**WEST SUSSEX COUNTY COUNCIL
STRATEGIC PLANNING CONSULTATION**

SUBJECT: LU-307-17

Sea Road – Promenade Shelter

Demolition of promenade shelter and construction of café and kite surfing school with roof terrace and associated works.

Ground floor plan | proposed

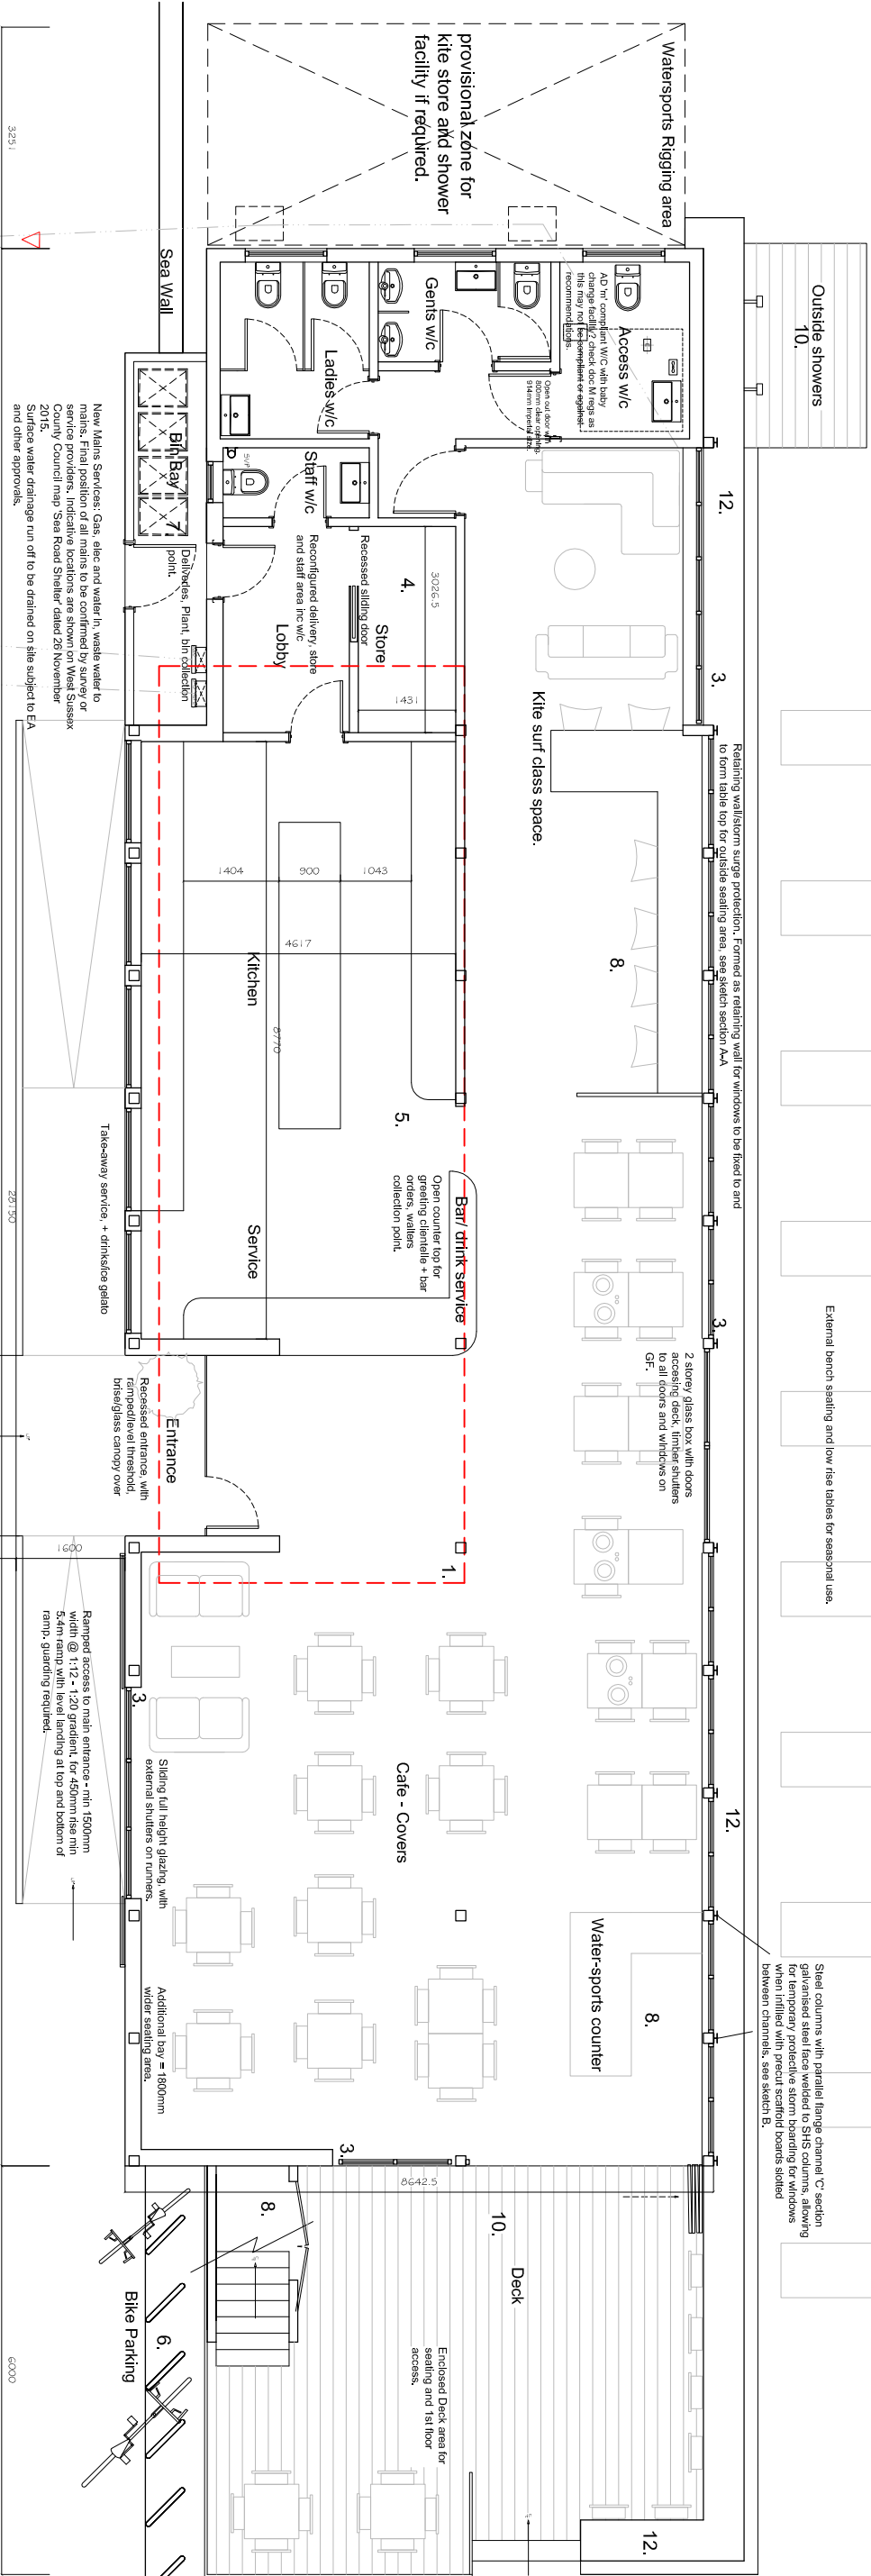
A bus stop is situated a few meters from the site, and the train station is located within 1-2km on foot. There should be some form of cycle storage provision.

No part of the development shall be first occupied until covered and secure cycle parking spaces have been provided in accordance with plans and details submitted to and approved by the Local Planning Authority.
